Recommendation Report for Planning Permission for Works or Extension to a Dwelling

REF NO: AW/113/22/HH

LOCATION: 11 Rucrofts
Aldwick
PO21 3SL

PROPOSAL: Single storey side extension.

11 Rooms	• proposed elevations mm section.	Apr. 22 1:100 1:50	Dwg. No 21/12/95/03	Rev.
----------	--------------------------------------	--------------------------	------------------------	------

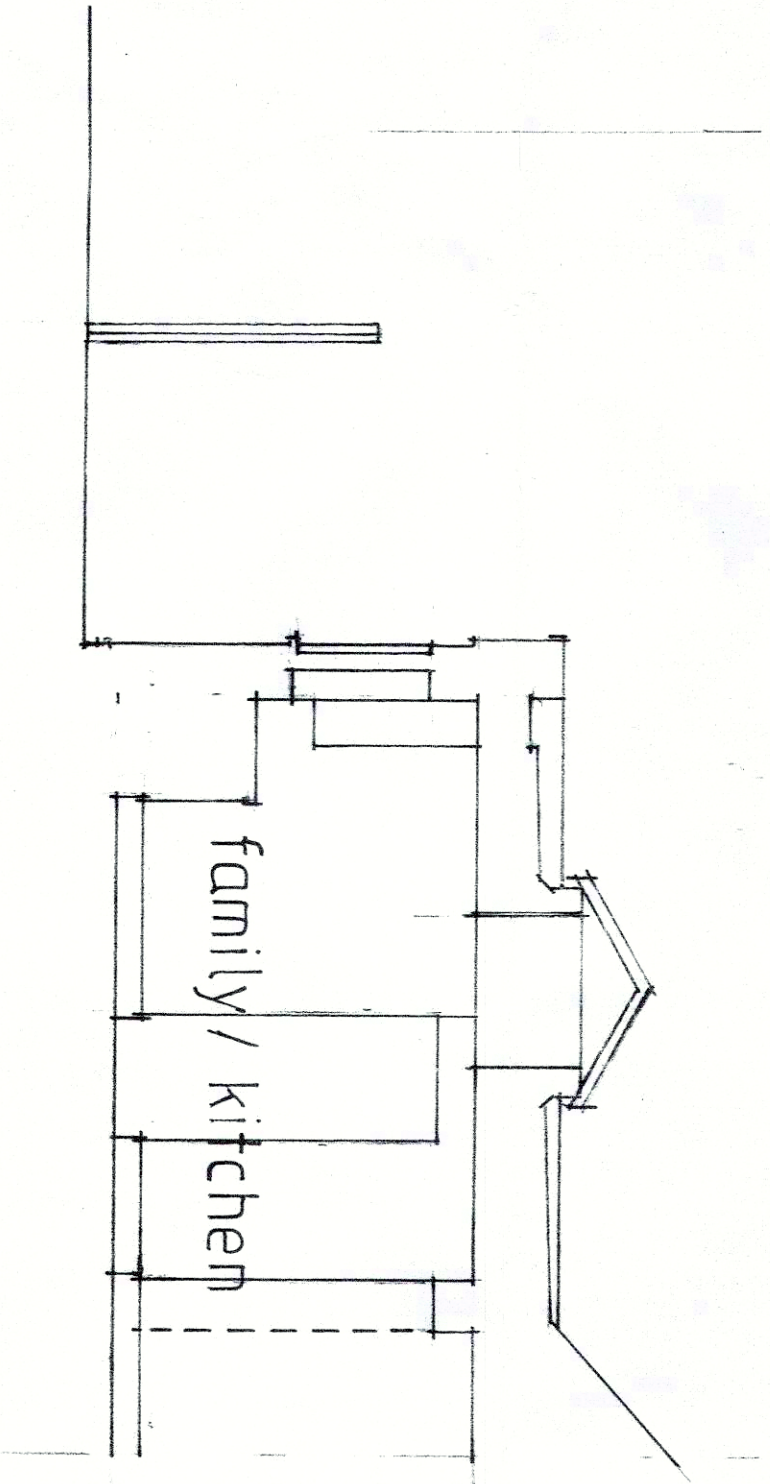
The proposal will be single storey, and of a modest size, projecting 4.45m from the side elevation with a width of approximately 8.4m. It will have a flat roof, which although differing to the pitched roof of the host dwelling, will not appear unduly out of place and is acceptable. It will integrate well with the existing, and have minimal impact on the visual appearance and character of the property. Being to the side, the proposal will not be visible from the street scene, and will only be partially visible from the wooded area to the side of the property. It will have no impact on the composition or appearance of the street, and is acceptable. Its design is in keeping with the character of the property, and the locality, and will have minimal harm on visual amenity.

The proposal will be single storey and have a flat roof at a height of approximately 3.1m. This roof will include a roof lantern which protrudes slightly above at a height of 3.53m, and will have no impact on residential amenity. The proposal itself will retain approximately 21.6m from the southern (rear) boundary, 2m from the west, and 17m from the north. These distances are in accord with D DM4 of the Arun Local Plan and are acceptable. The property itself is at the end of a row of properties, with the proposal located next to the boundaries not shared with any neighbours. Therefore, it will result in no overbearing or overshadowing of neighbouring properties, and will have no harm on residential amenity.

In addition to the roof lantern, the proposal will also feature a set of doors to the south elevation, window to the west, and a window and door to the north. As the closest boundaries to the proposal are not shared with any neighbouring properties, none of these features will result in any overlooking, as instead they face parts of the garden. They pose no risk of harm to residential privacy or amenity and are acceptable.
